**Response to the Non-Statutory Consultation on Proposed Changes to the Application by Medworth CHP Limited for an Order Granting Development Consent (DCO) for the Medworth Energy from Waste (EfW) Combined Heat and Power (CHP) Facility**

We are writing on behalf of Cambridgeshire County Council (CCC) and Fenland District Council (the Councils) in response to the non-statutory consultation on Proposed Changes to Medworth CHP Limited's (the Applicant's) application for a DCO to construct, operate and maintain an EfW CHP Facility on the industrial estate at Algores Way, Wisbech, Cambridgeshire.

**Figure 3.19i**  
**New Bridge Lane access proposal**

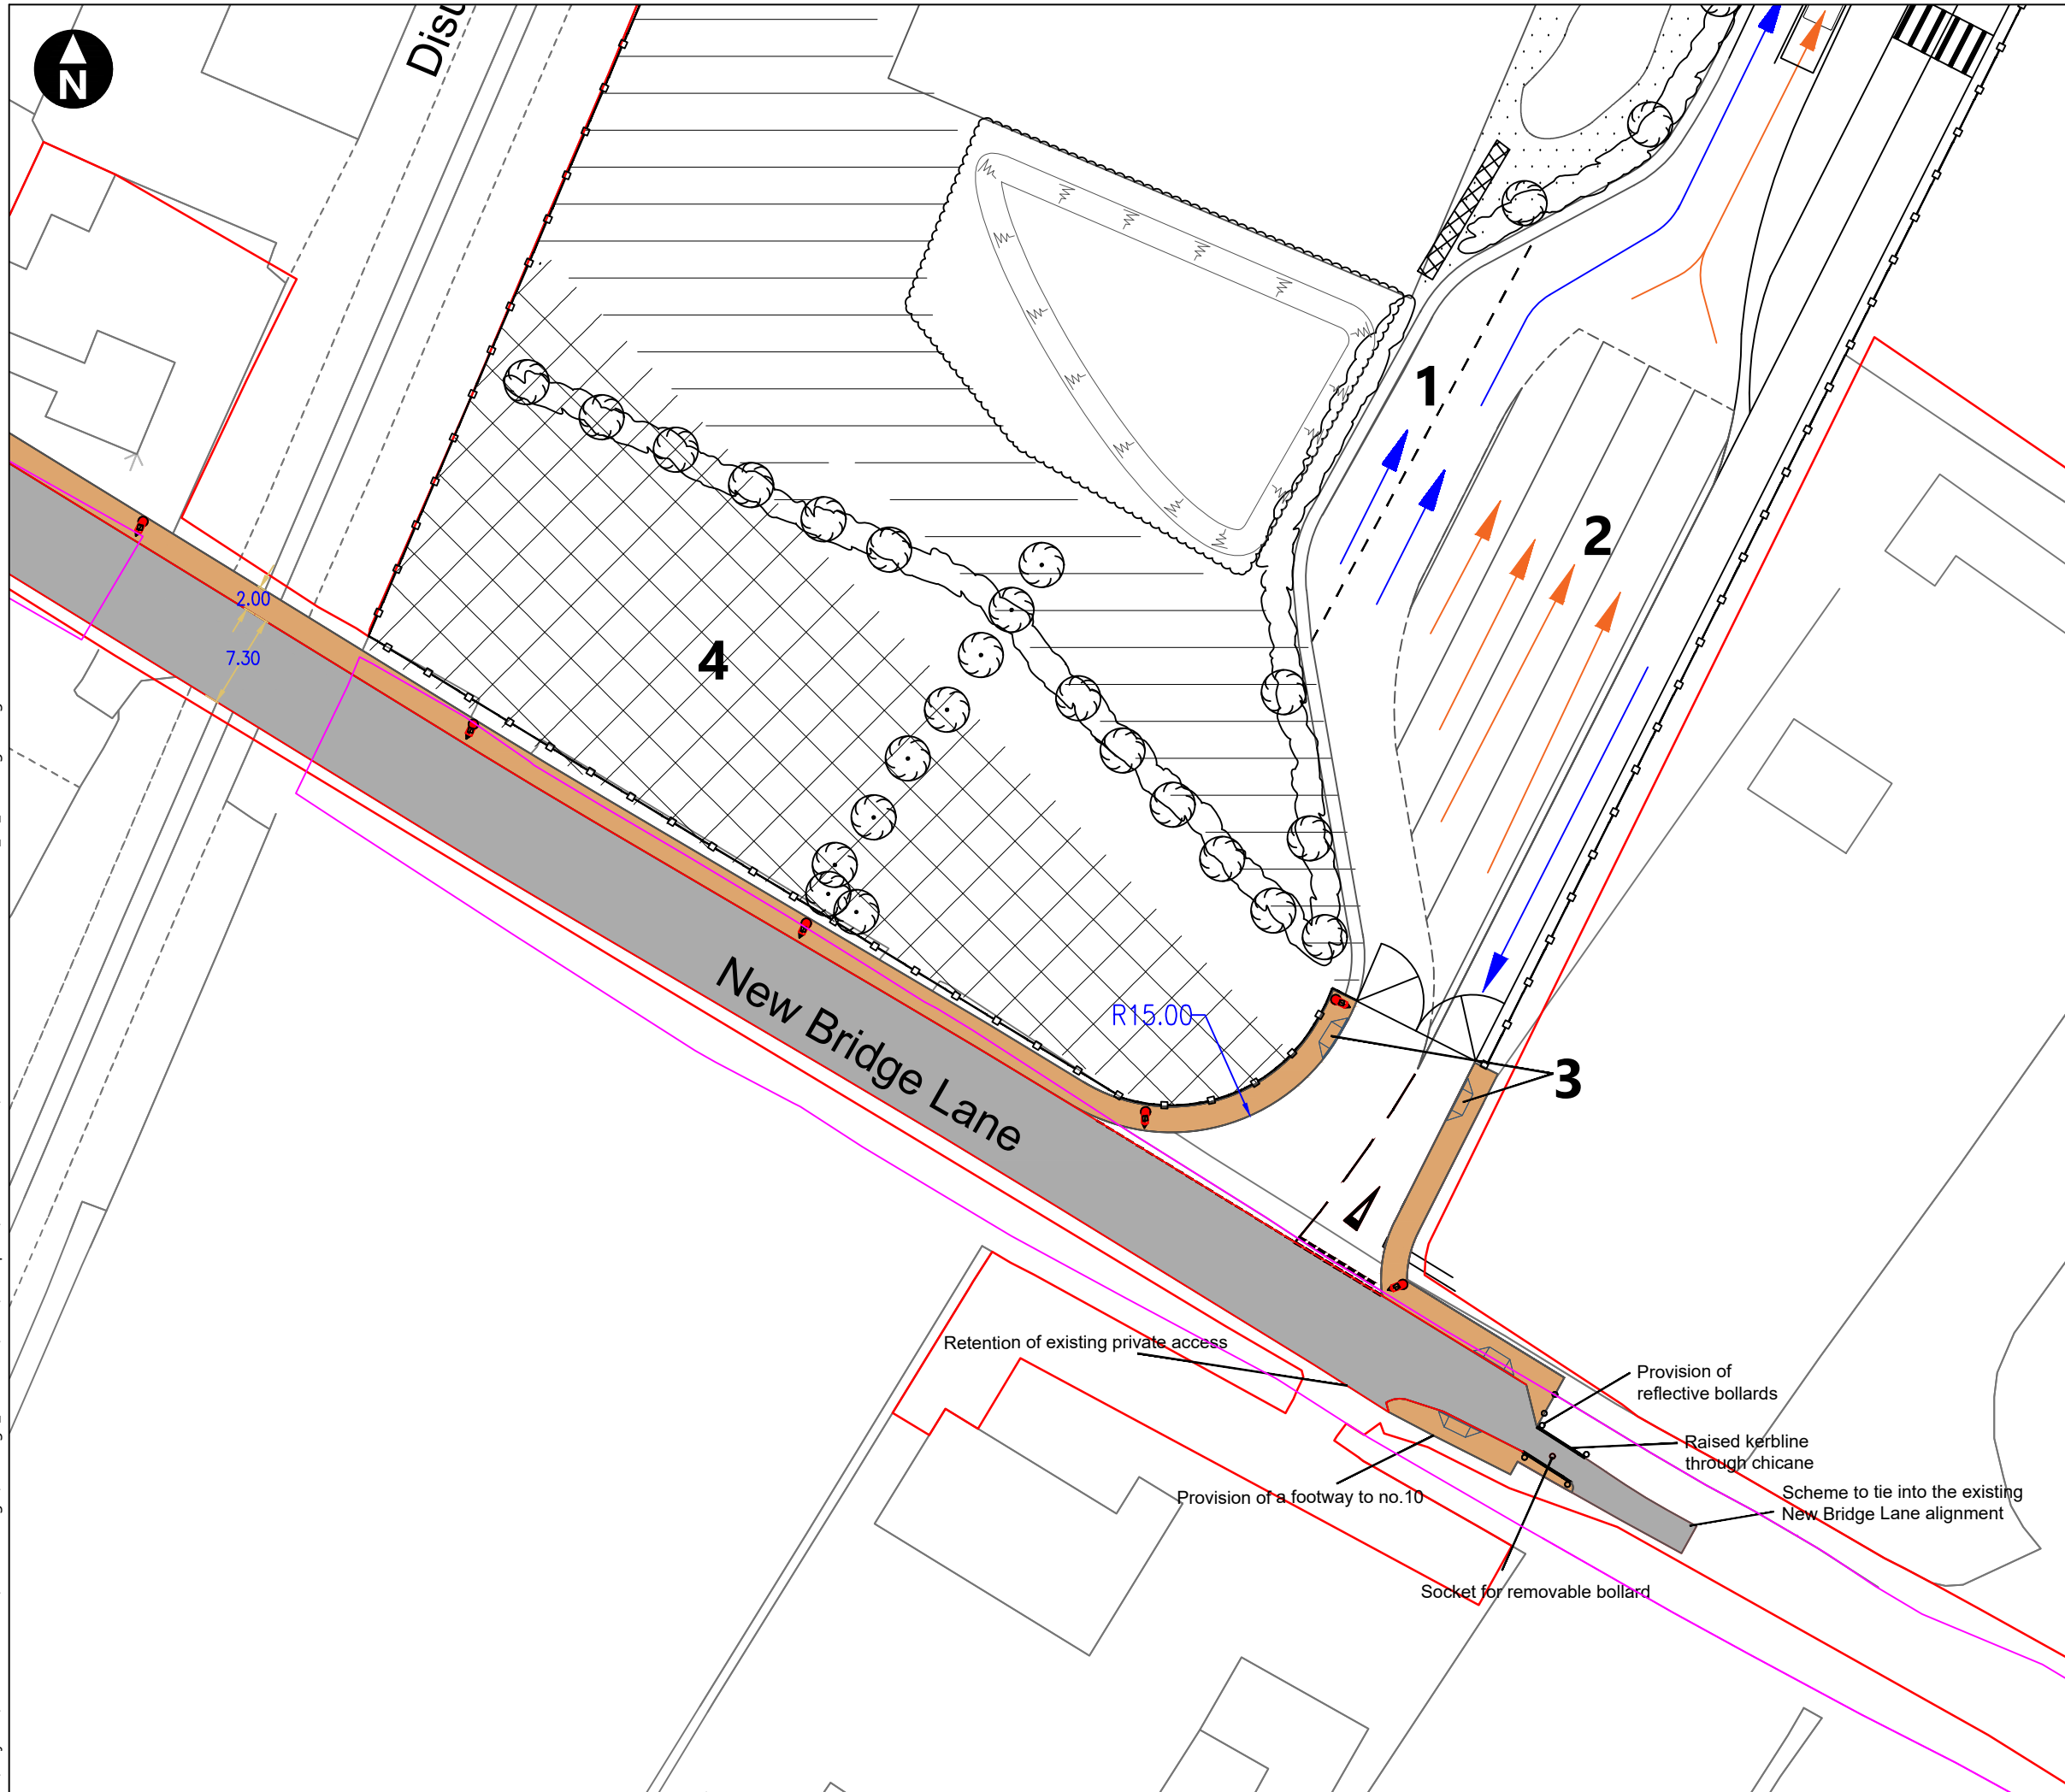
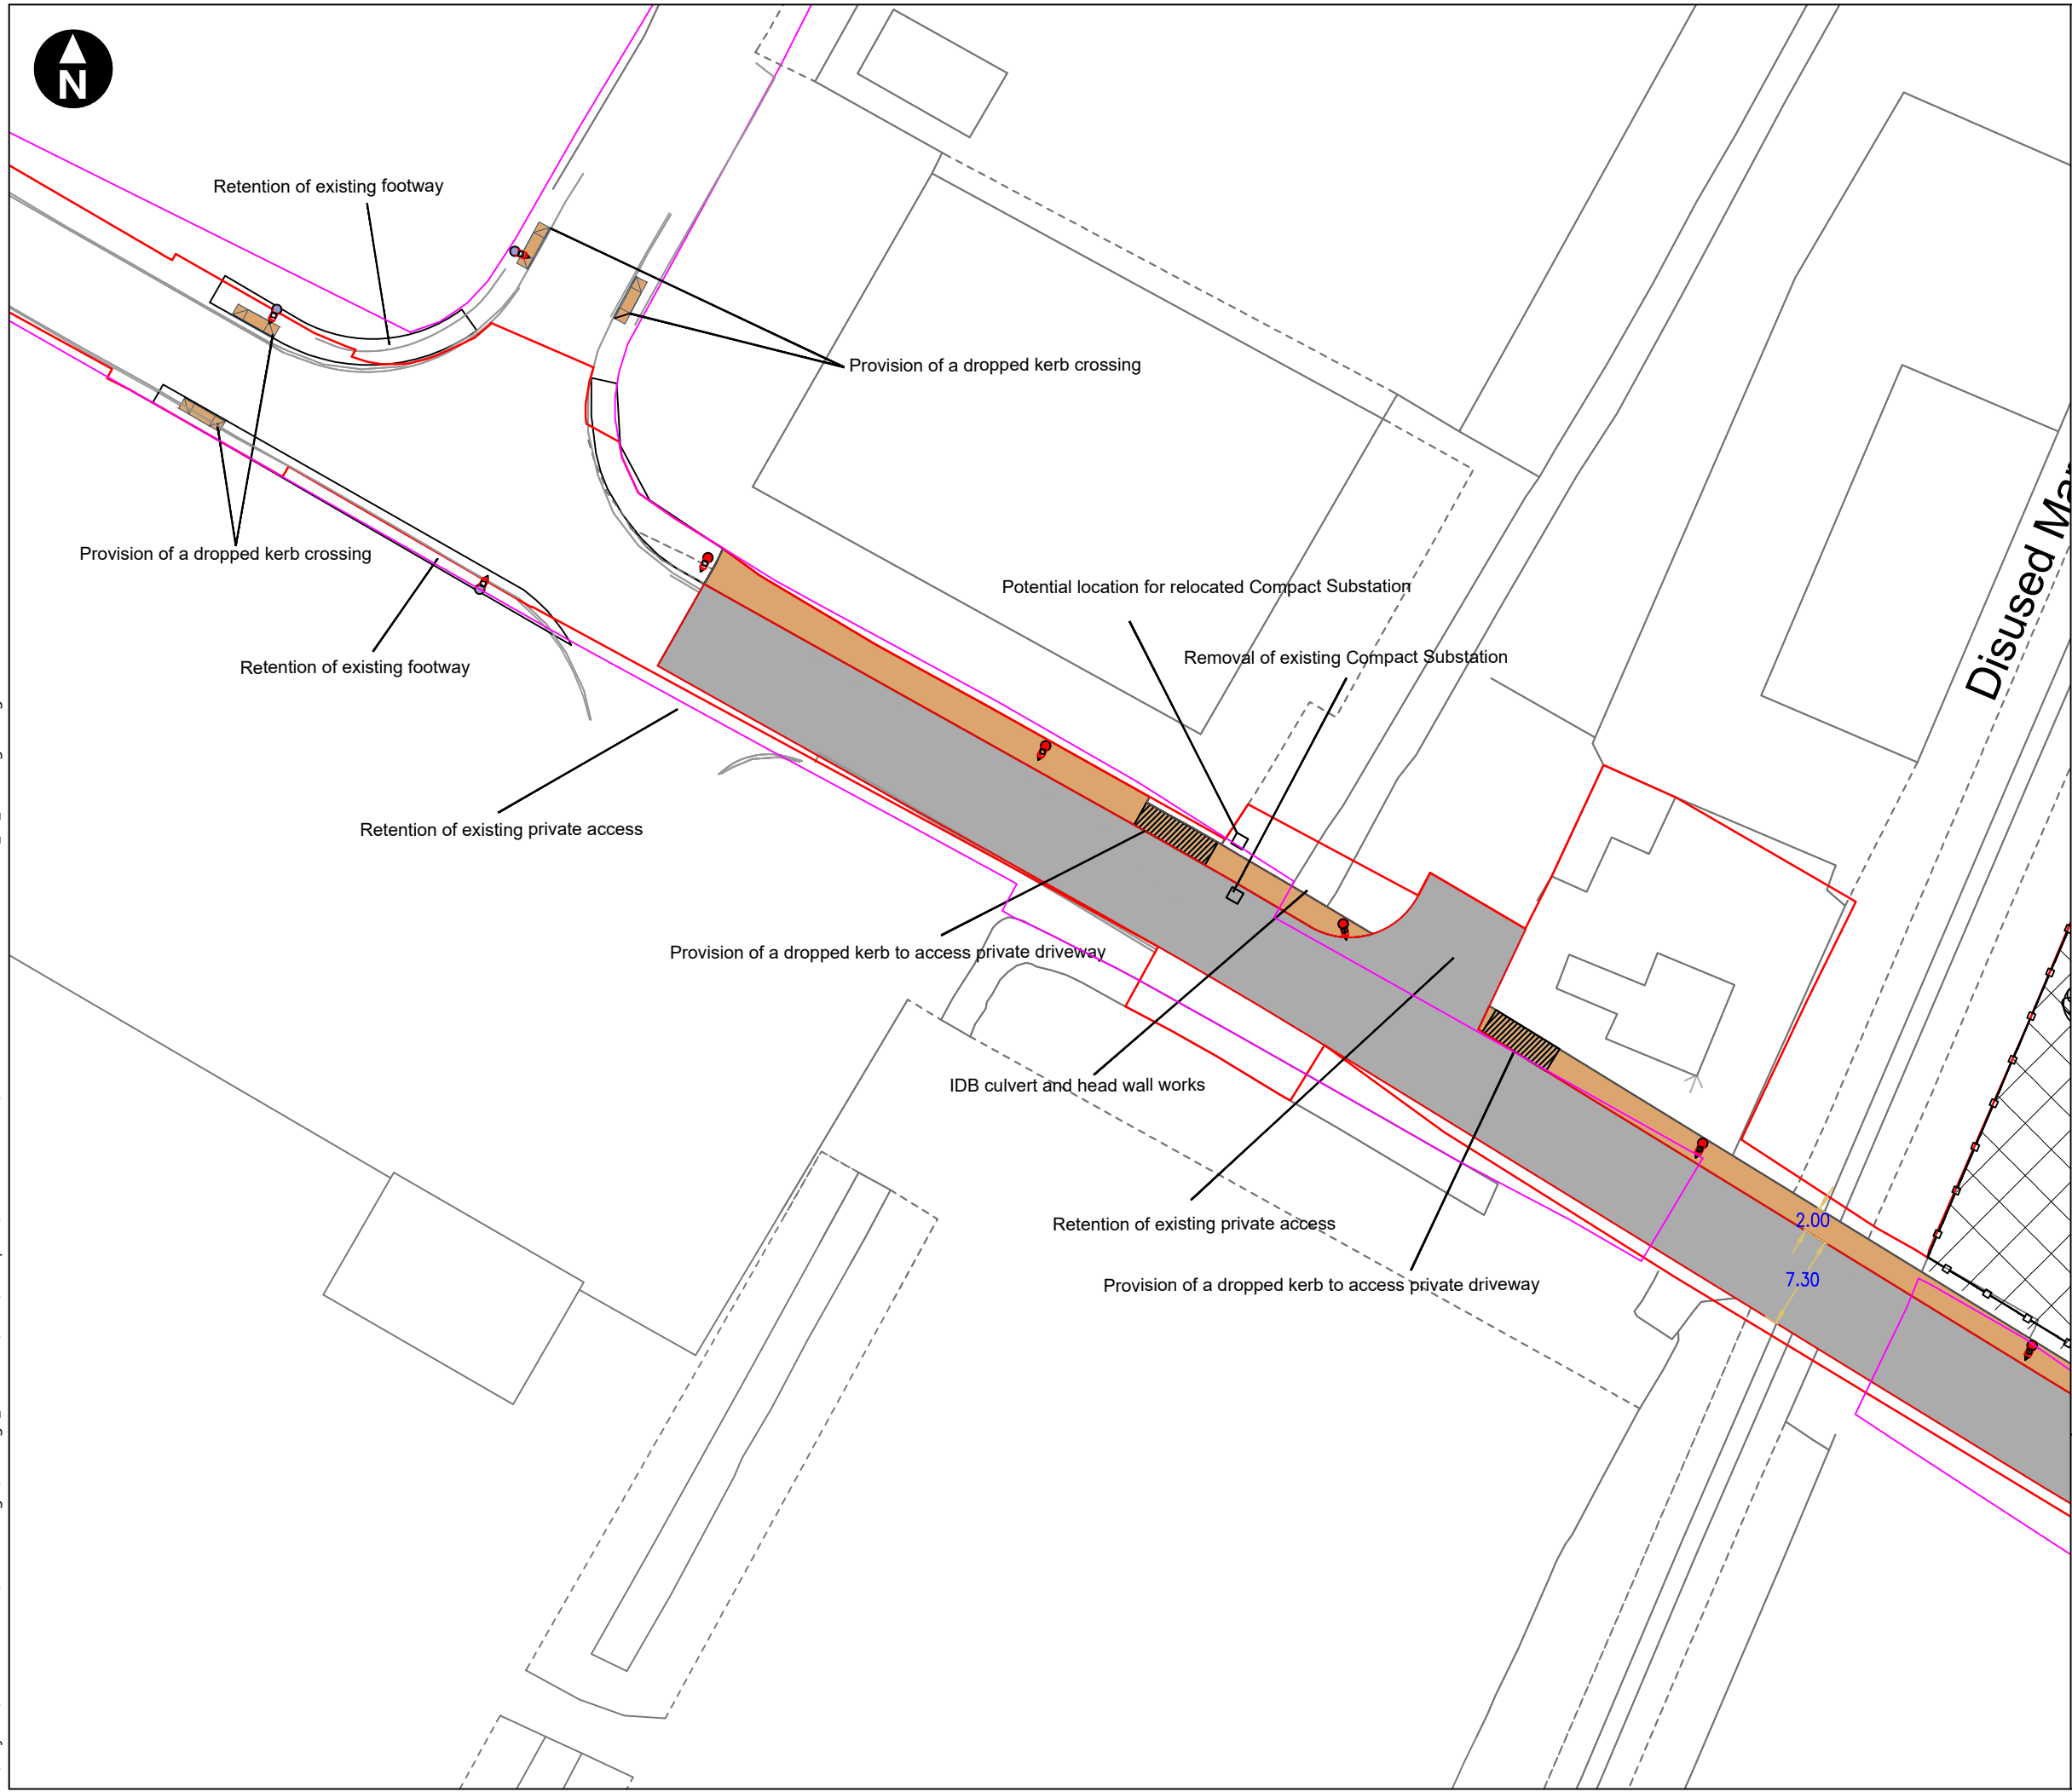
- As raised by CCC at ISH6 on 26<sup>th</sup> June 2023, the Councils question whether the Proposed Changes adequately extend the DCO boundary, and whether sufficient powers of compulsory acquisition are included to ensure that the revised junction layout at New Bridge Lane/Cromwell Road can be delivered within the Order limits and subsequently (where appropriate) dedicated as highway. CCC continues to engage with the Applicant in respect of the junction design to achieve clarity on this matter.

- The Councils acknowledge that the Applicant is now proposing to modify the original design to construct central traffic islands, allowing the safe signal control of right turning vehicles from Cromwell Road towards the development. CCC notes that the provided 'Linsig' traffic modelling does not represent the traffic signal
